RELEVANT REPRESENTATION ON BEHALF OF ENCIRC LIMITED

- 1.1 This representation is made on behalf of Encirc Limited ("Encirc") in relation to the HyNet Carbon Dioxide Pipeline Development Consent Order Application ("the Project").

Figure 6.1 – Extract of the Ince Park Plastics Masterplan - Drawing Number: 20039-FRA-XX-00-DR-A-90-0005 P2 approved under application no. 21/04076/FUL and works no.3, EN070007-D.2.4-WP-Sheet 1 [AS-012].

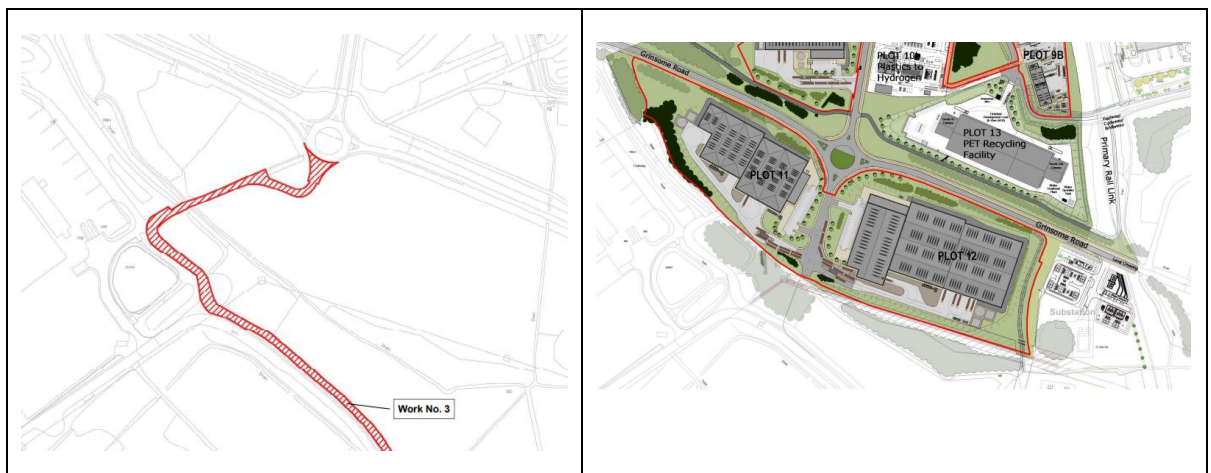
- 4.1.1.2 Once this permission has been implemented, part of the proposed Project access route (Works No.3) will be affected.
 - 4.1.1.3 Further future development to realise the full potential of the Site is also planned and well publicised. This includes an ultra low carbon furnace as well as further rail development on site (trials have been taking place to determine feasibility).

- 4.1.2 **Project Access:** Encirc is concerned that the proposed access route for the Project, as shown on Works Plans 1 (Work No.3), will impact its operations. Particularly the parts of the proposed internal access routes and to the south of the railhead. As stated, part of the proposed Project access route will cease to exist following construction of Encirc's new distribution hub.
